Dubbo Hospital Stage 4 Redevelopment

Response to Submissions – SSD 16_7720

PREFERRED CONCEPT LAYOUT
DRAWING NO. 16S1359100-08-00 SHEET 01 OF 03

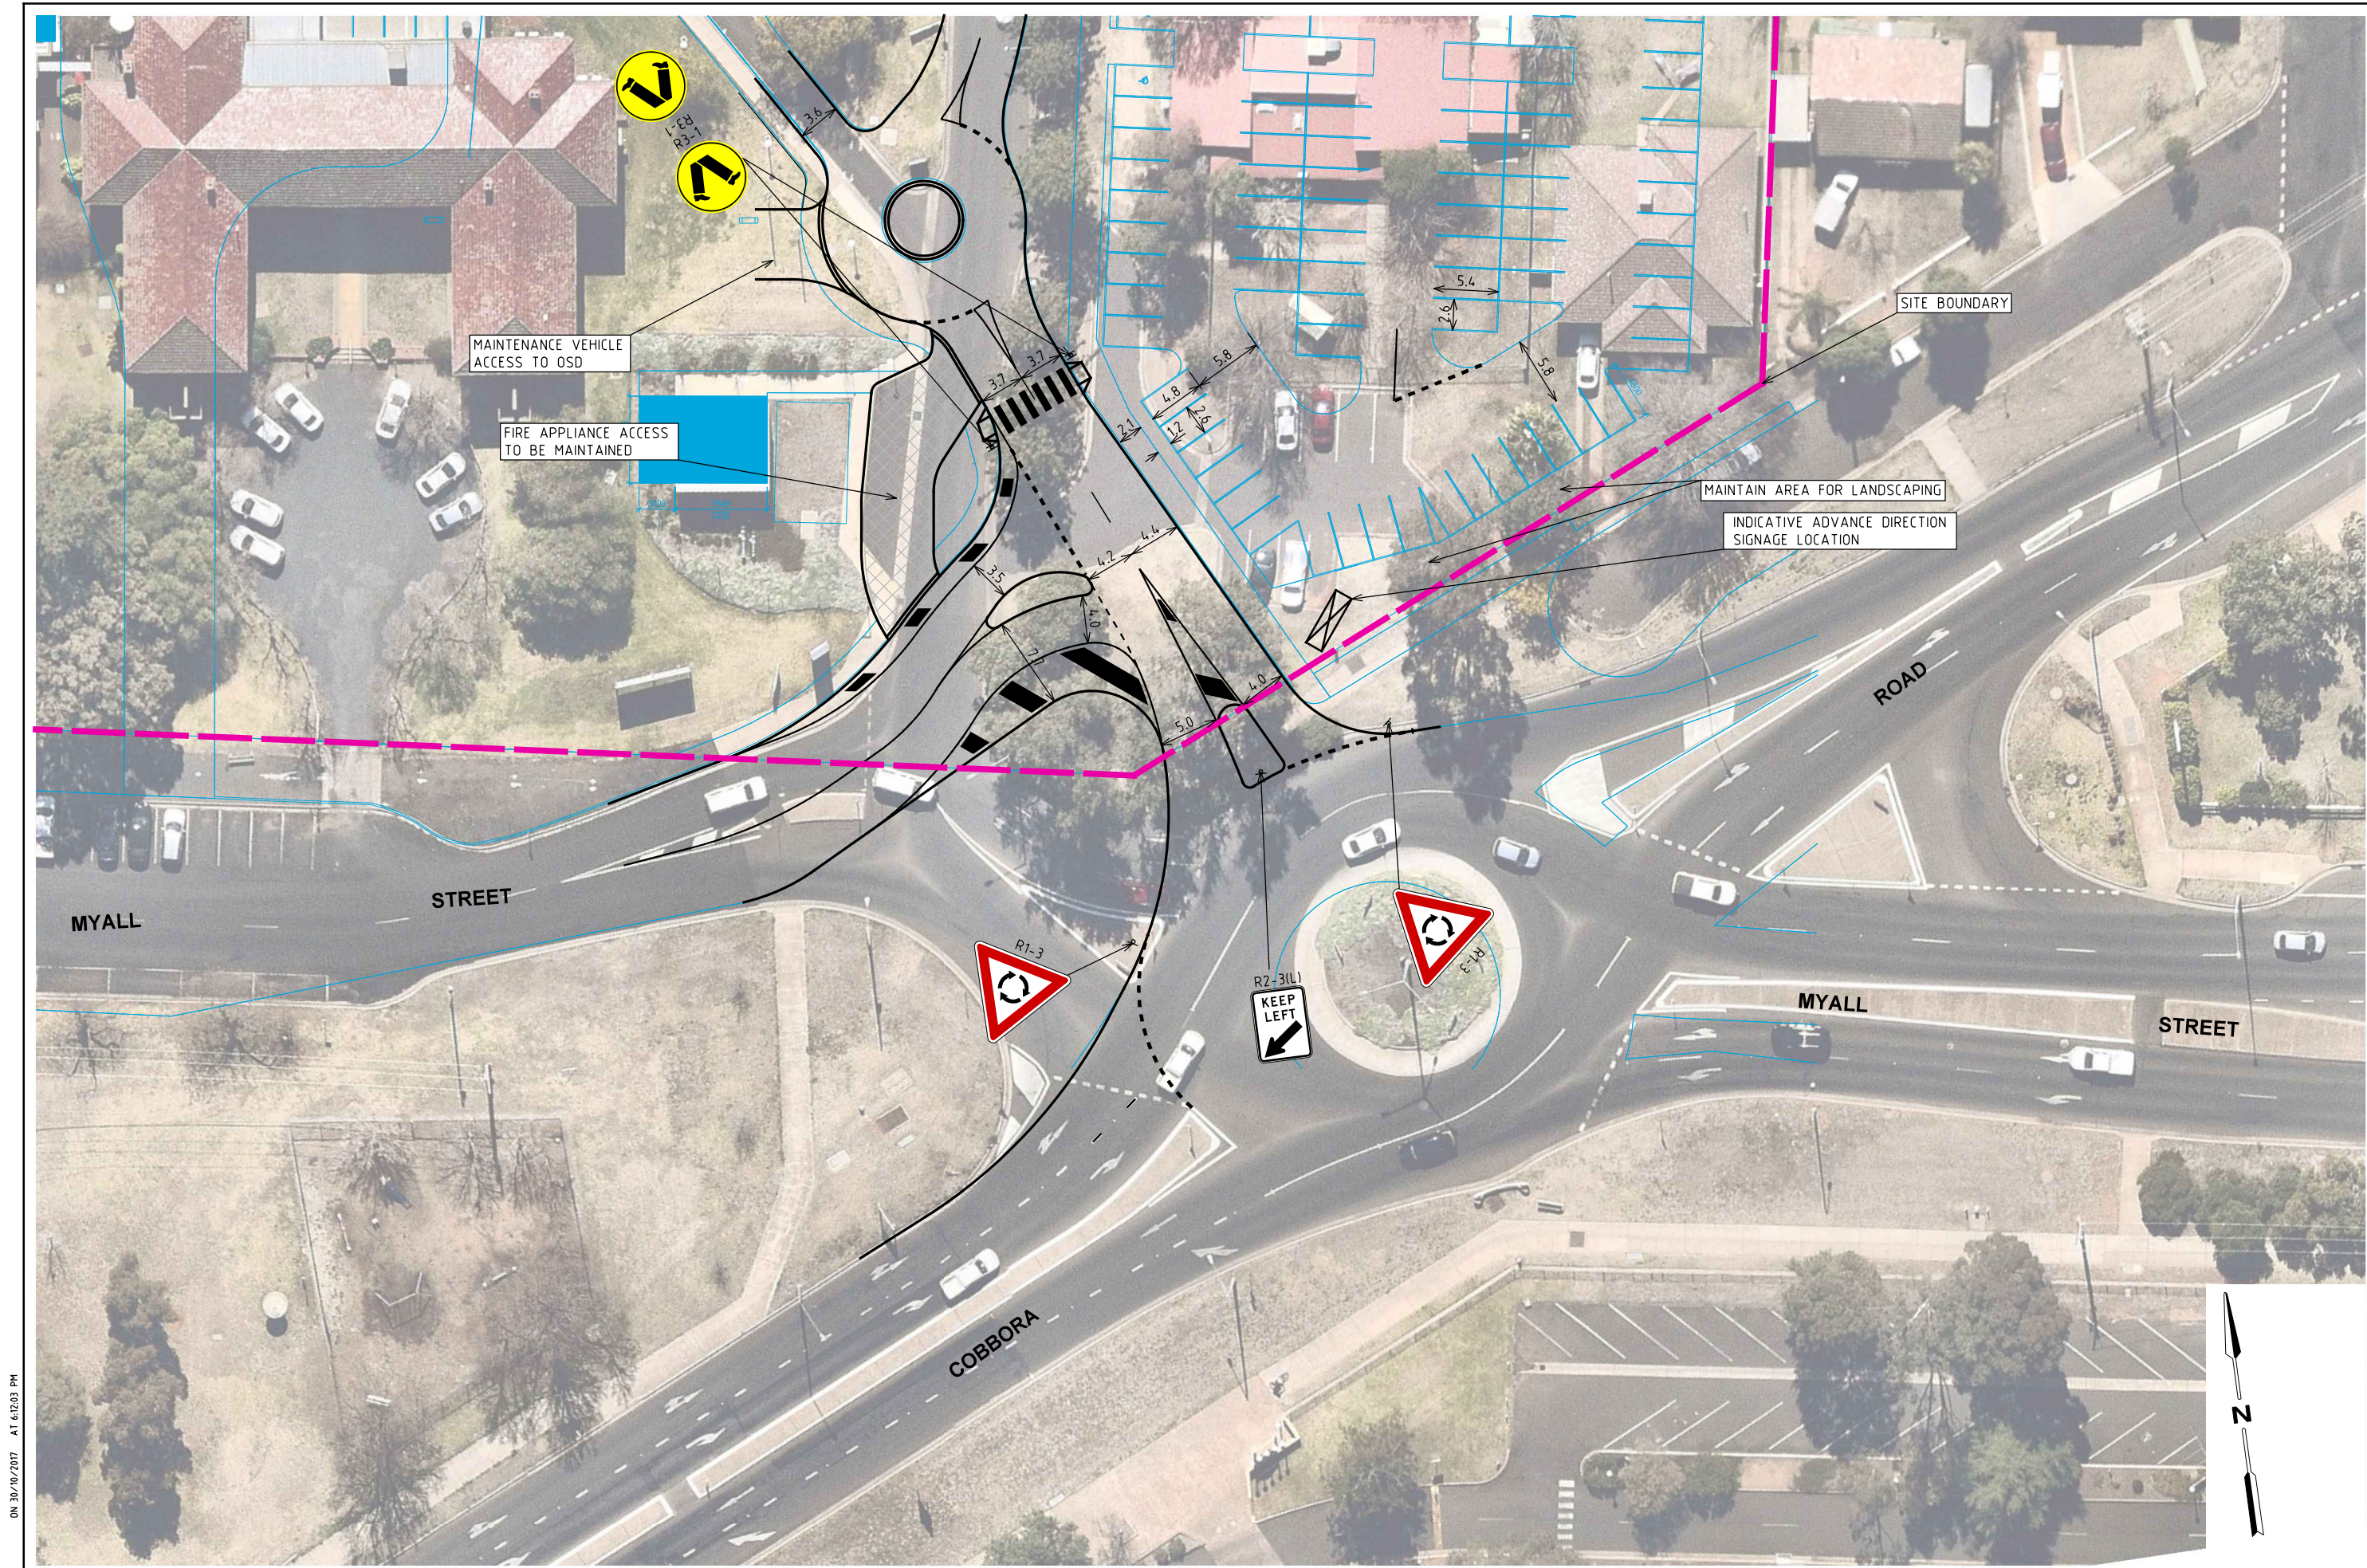
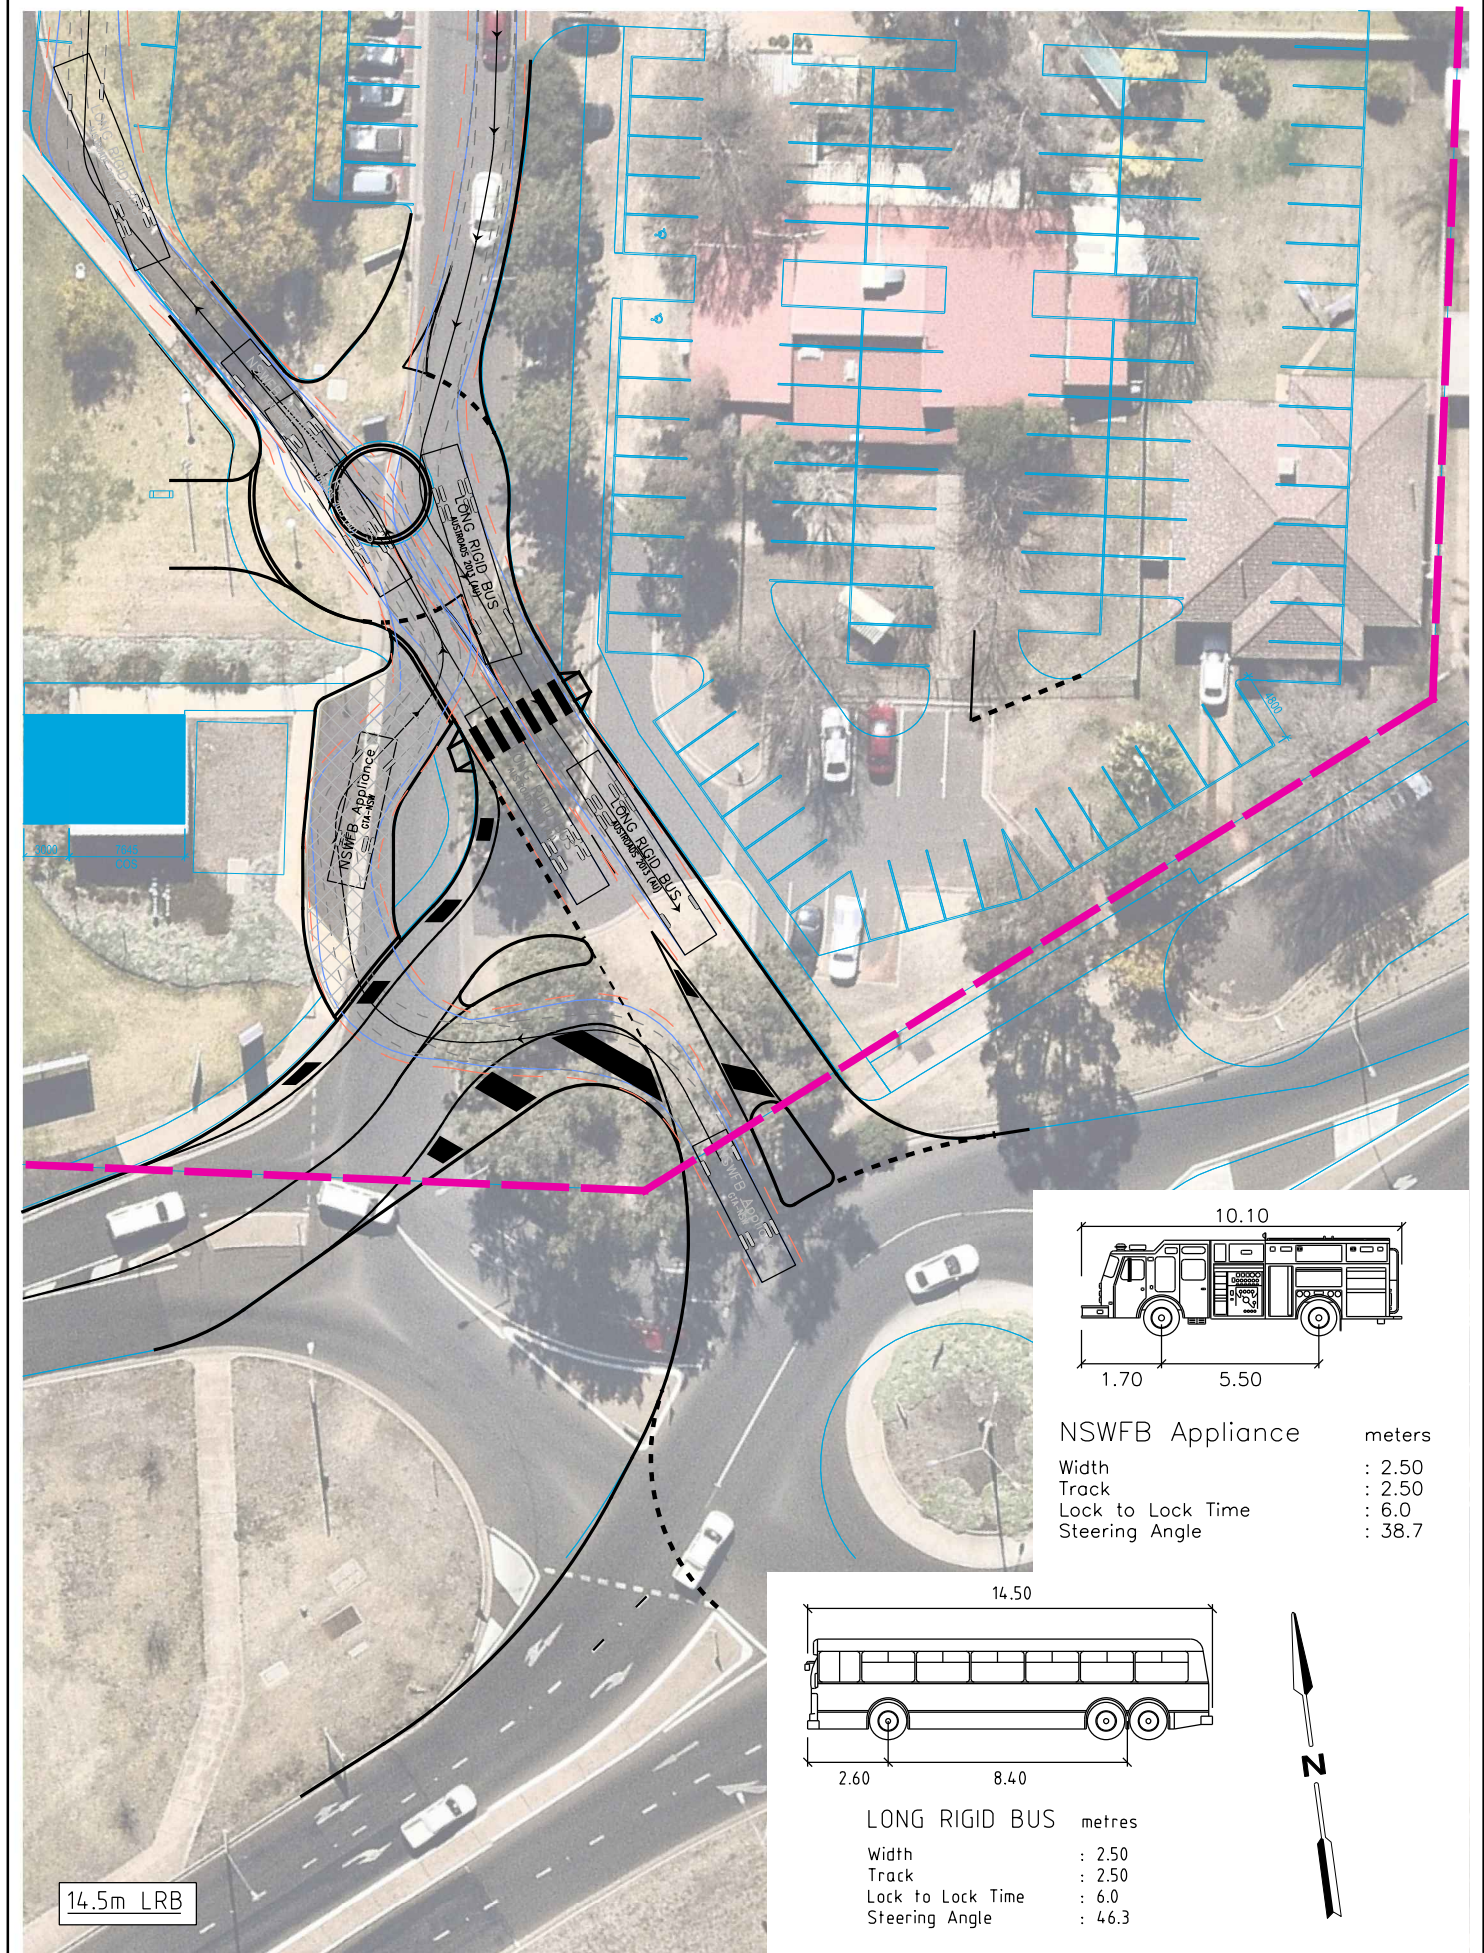
There are significant concerns which were initially flagged with the geometric realignment of Myall Street into the hospital property and intersection with Cobbora Road, and the potential traffic conflict in this locality, that have not been addressed to the satisfaction of Council. Council is disappointed that there has not been ongoing consultation on the transportation strategy and the potential opportunities available to enhance the long term accessibility needs for the Dubbo Base Hospital and the community.	
Further concerns are raised regarding the proposed Myall Street realignment and associated intersection arrangement with McGuinn Drive and to a lesser extent the new access onto the Cobbora Road roundabout in that it may not provide the optimum outcome. It is noted that it would be some time before the transportation improvements would be implemented. As such, a holistic approach should be undertaken of the Dubbo Base Hospital redevelopment, with consideration of all the mitigating factors including:

4. The proposed traffic management comprising of the Myall Street realignment, McGuinn Drive intersection and new Cobbora Road access and transition appears to promote an environment for traffic and pedestrian conflict with constrained turning paths, short travel distances for driver interpretation and decision making, no vehicle separation into Myall Street.	Refer to comments above. In response to the submissions received, and following further consultation with Council and RMS, the access arrangements off Myall Street and the Cobbora Road roundabout have been amended. As noted above, the revised layout offers a number of benefits compared to the existing access arrangements. In response to this particular concern, the identified issue of short travel distances within the hospital for driver interpretation and decision making is removed, with appropriate advanced warning and directional signage, as well as hospital identification signage, able to be provided on the adjacent road network to guide any unfamiliar users into the hospital. This would reduce the risk of vehicle conflicts.

3. The proposed re-alignment of Myall Street being a public road into Dubbo Base Hospital property. Property adjustment required.	As noted above, the revised layout removes any impact (by the Myall Street alignment) on property boundaries.
